RE: **Glenrio Apartments,**  
Town of Atrisco Grant, APU #8, Tracts 223 & 224  
**Erosion and Sediment Control Plan**

File # **J10/E043**

Based upon the information provided in your submittal received 12/30/2013, the above referenced plan cannot be approved for **Building Permit**, until the following issues have been addressed on this Erosion & Sediment Control (ESC) plan.

ESC 103
OF

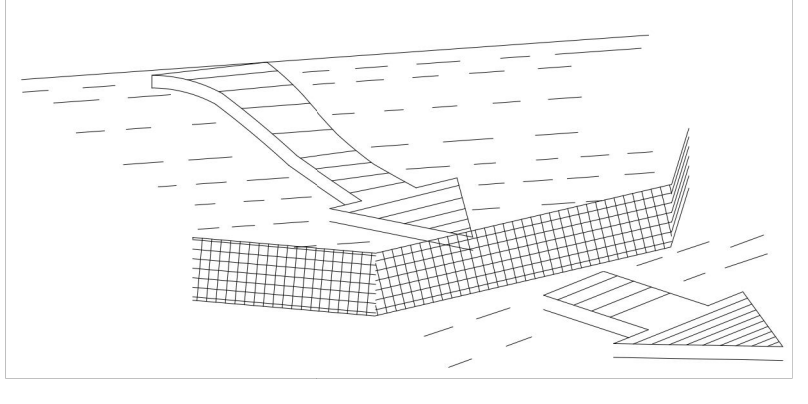
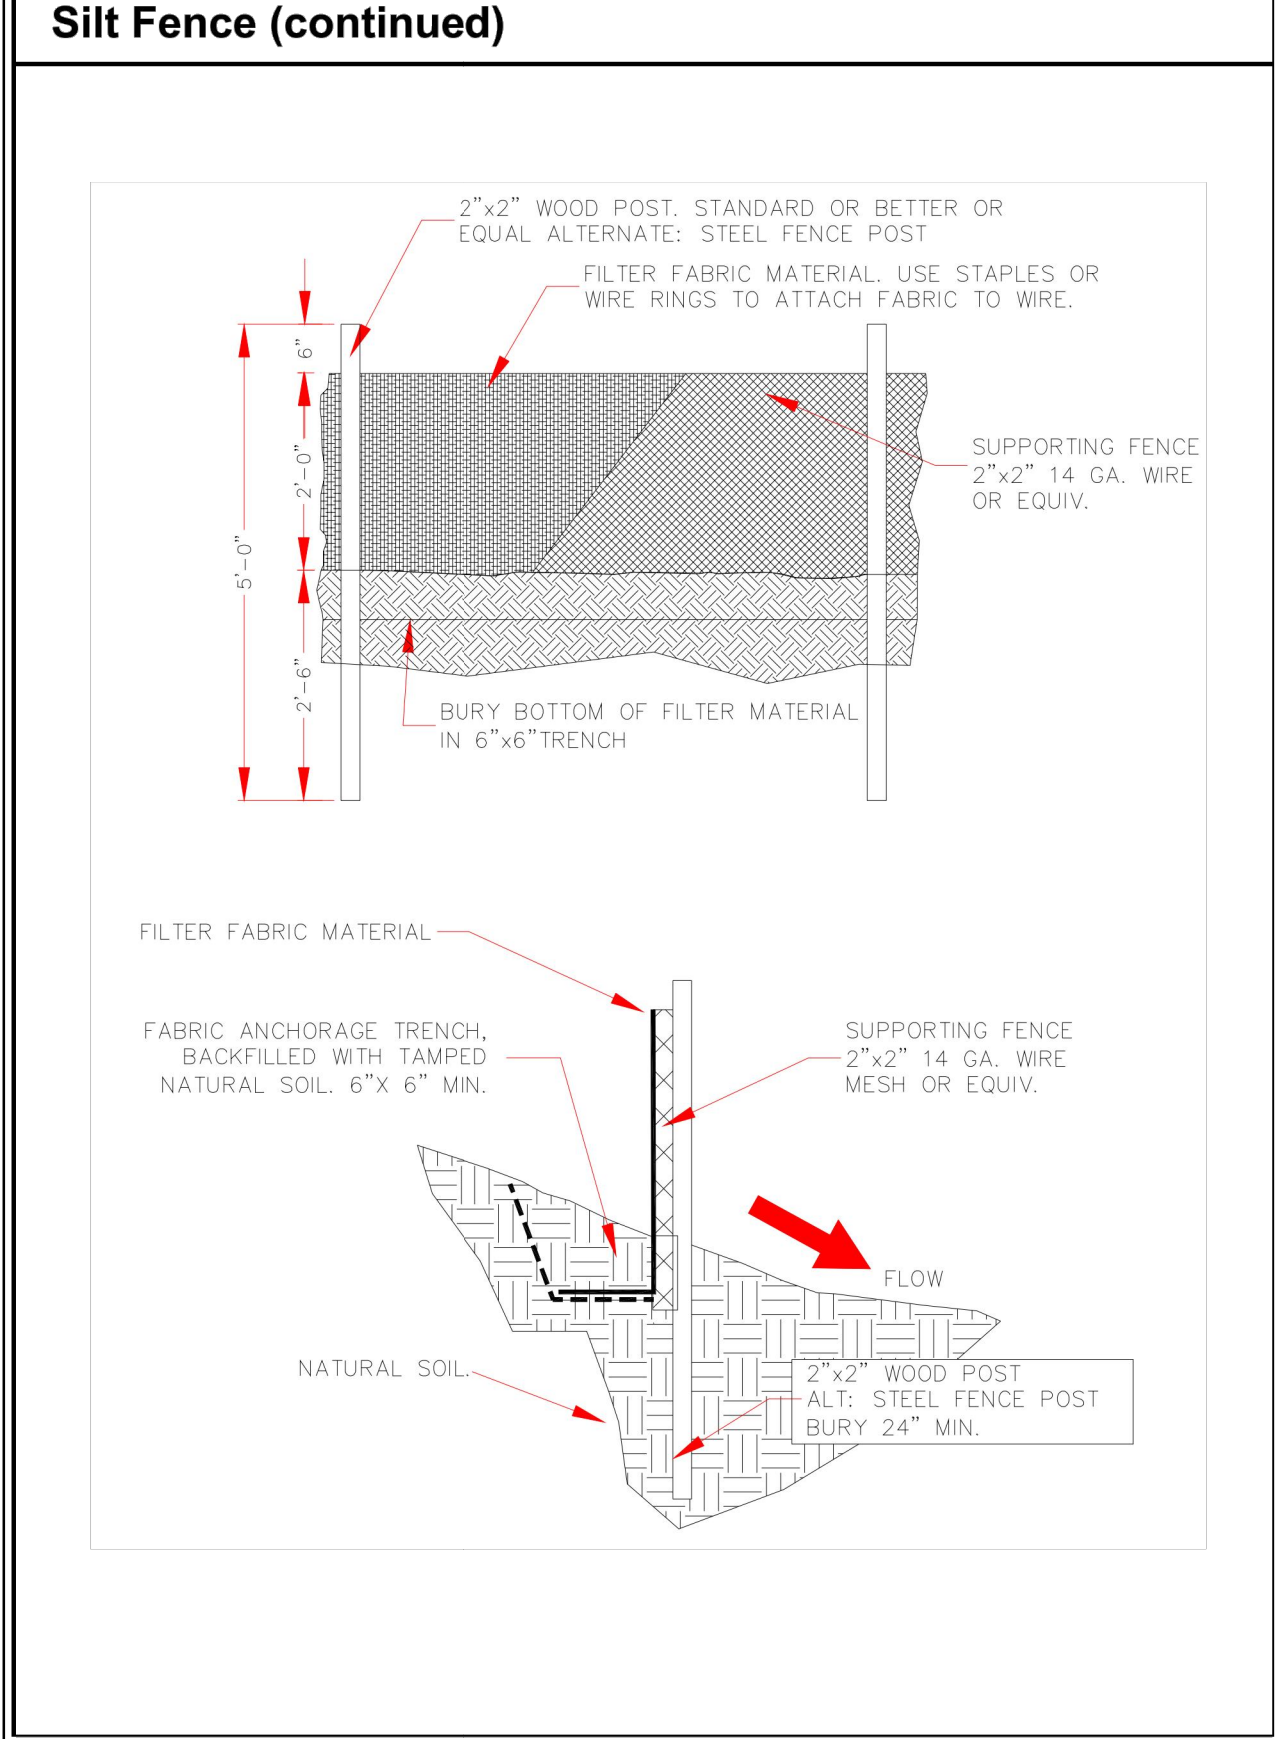
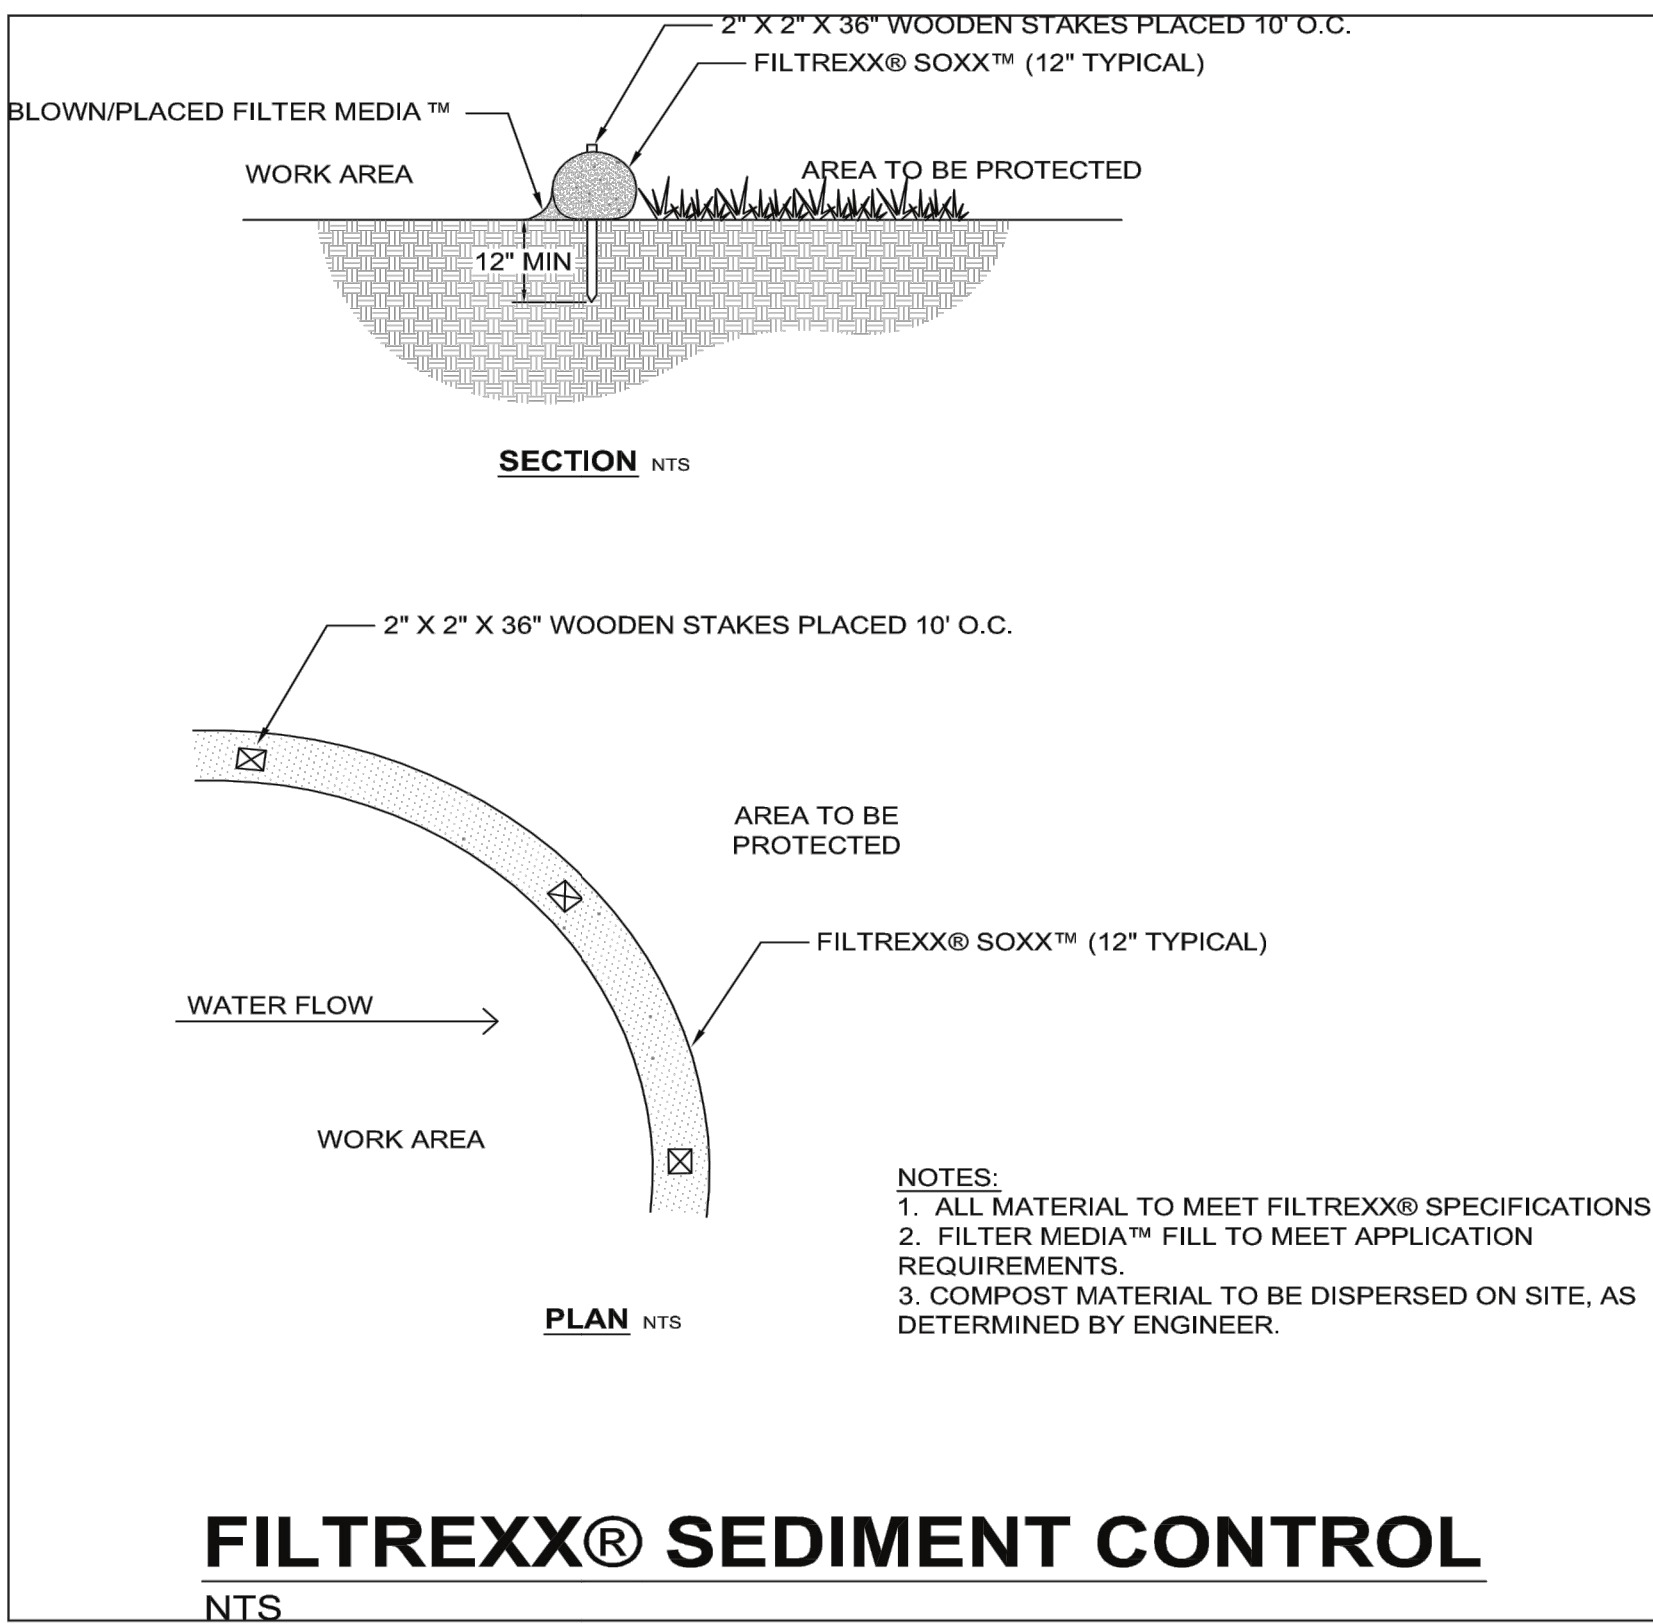
1. The vicinity map should include reference to City Zone Atlas Map No. J-10.
2. Provide a detail sheet for applicable BMP's as part of this sealed submittal, not just as reference to the SWPPP.
3. Locate and detail/dimension the Construction Entrance(s) on the ESC plan (50-ft minimum length).
4. Identify and dimension the Sediment Pond(s) required for ESC, and provide BMP's for the pond outfall locations to ensure sediment control during construction.
5. Clarify the limits of "Perimeter BMP's and applicable details. This plan appears to not have any perimeter sediment control on the southern boundary of the site.
